From: Andrew Knowles [REDACTED]
Sent: 09 October 2019 08:02
To: Zac Denton <Zac.Denton@arun.gov.uk>
Subject: Re: R/194/19/HH - Confirmation of materials

Subject: R/194/19/HH - Confirmation of materials

Drig No.: SBS/532/05A

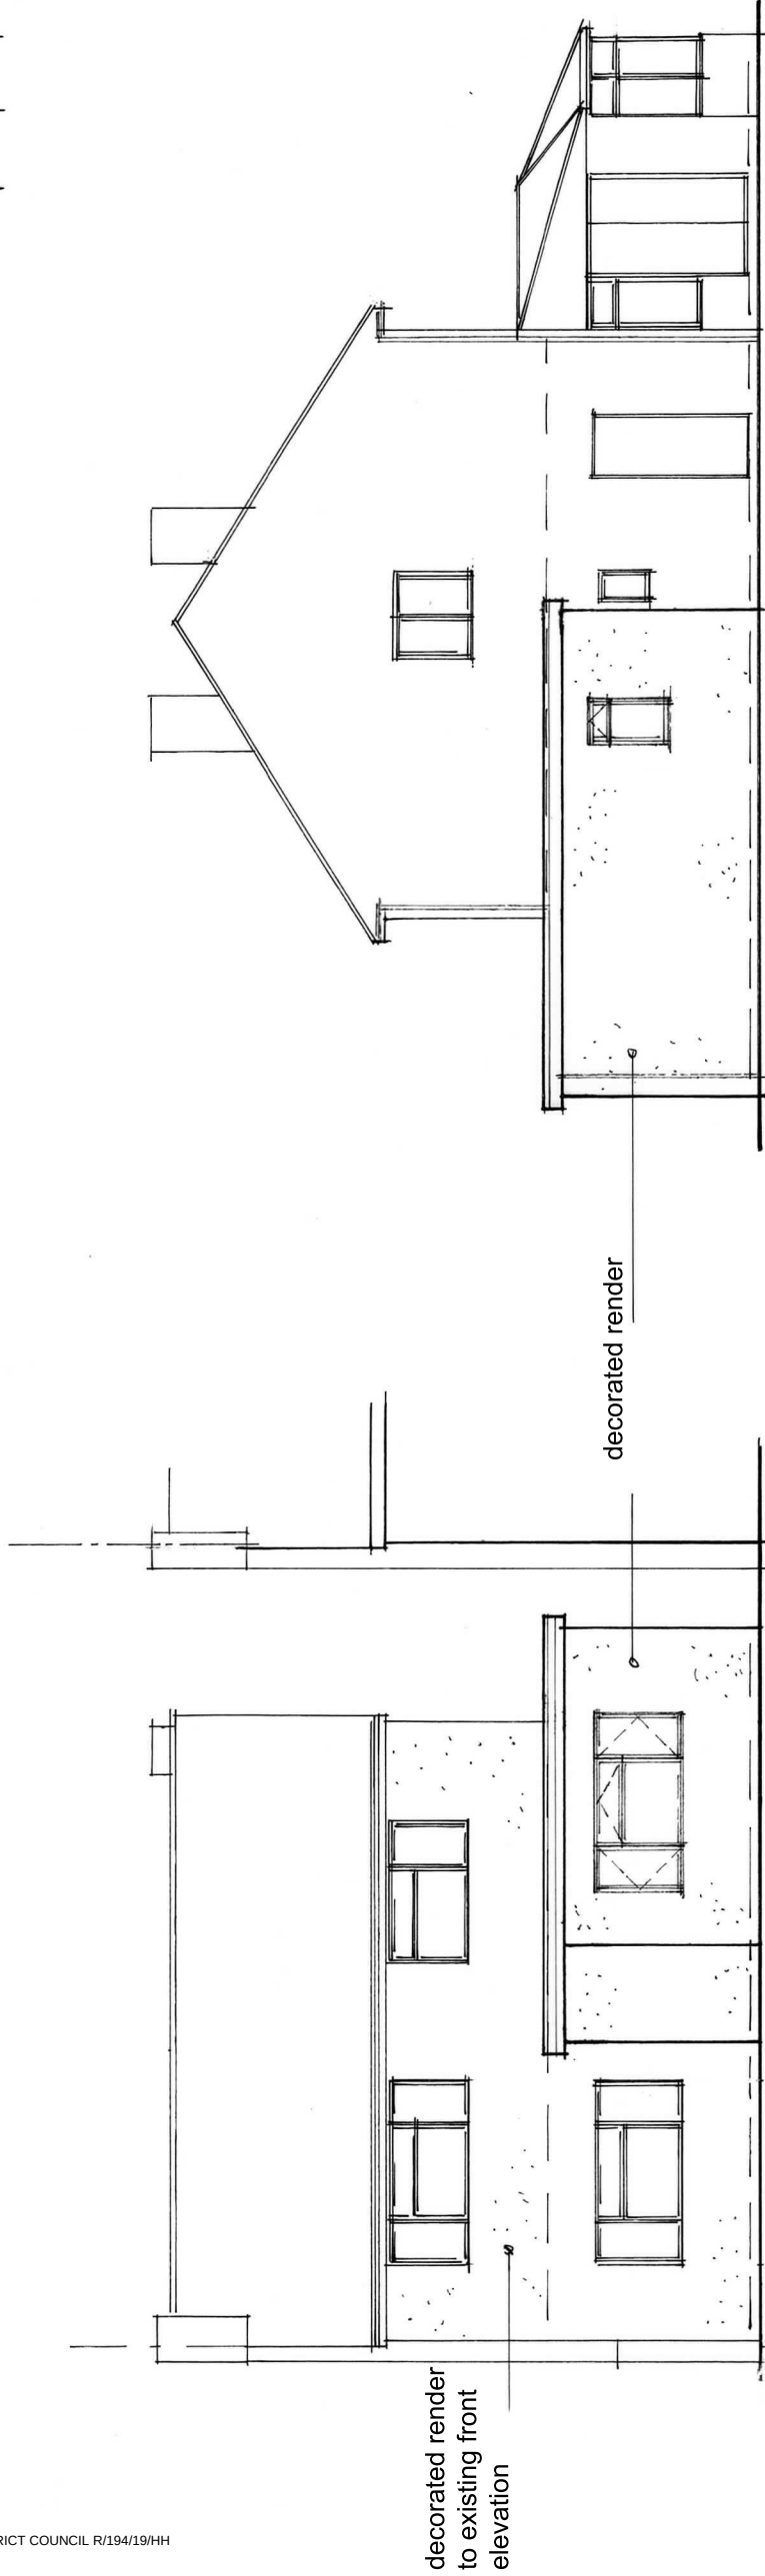
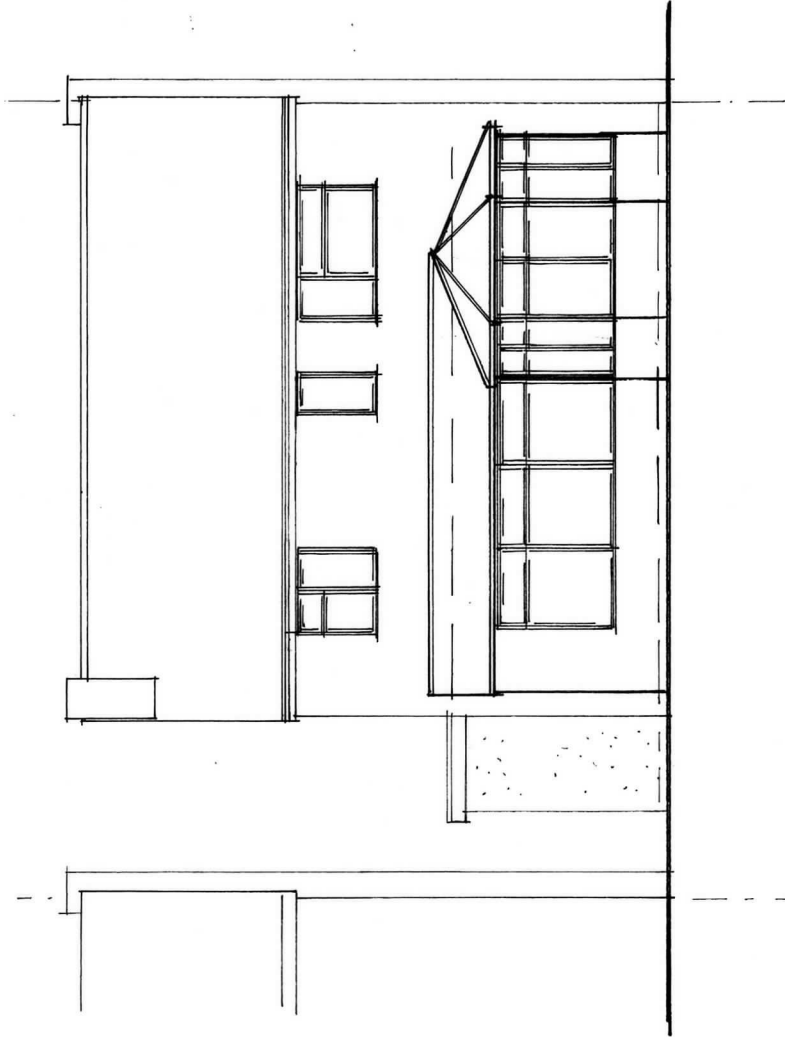
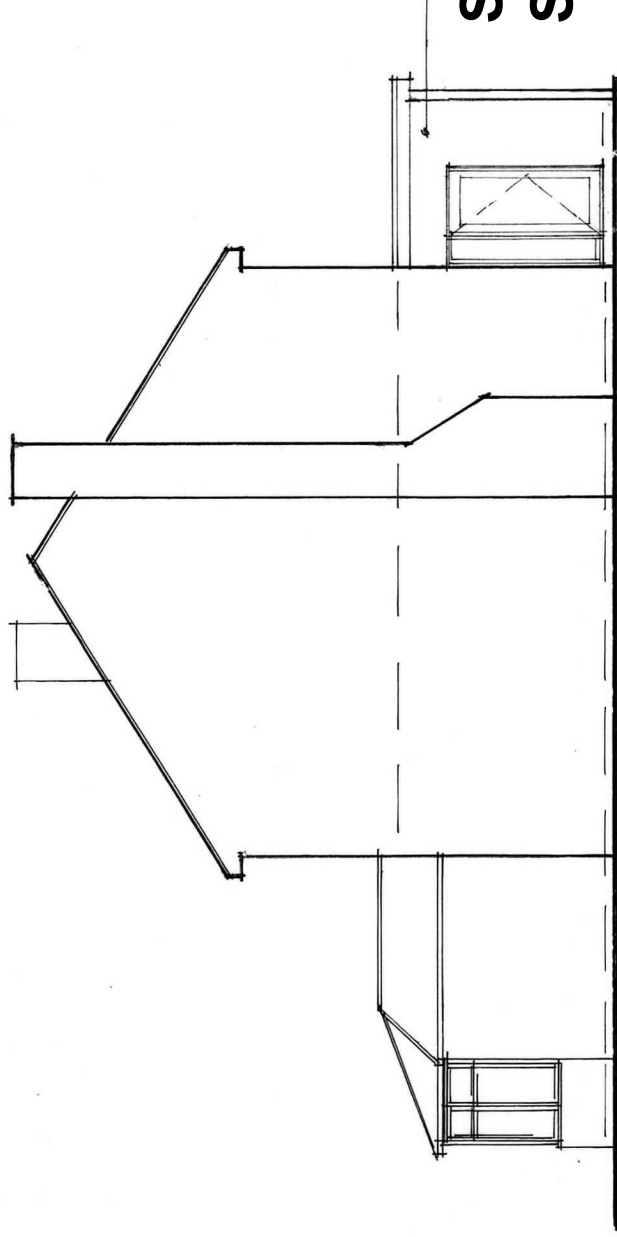
Are you able to confirm the details of the proposed materials for the above application?

The walls finishes are decorated render (as stated on drawing 05A) and the flat roof will be weathered with GRP or bituminous felt.
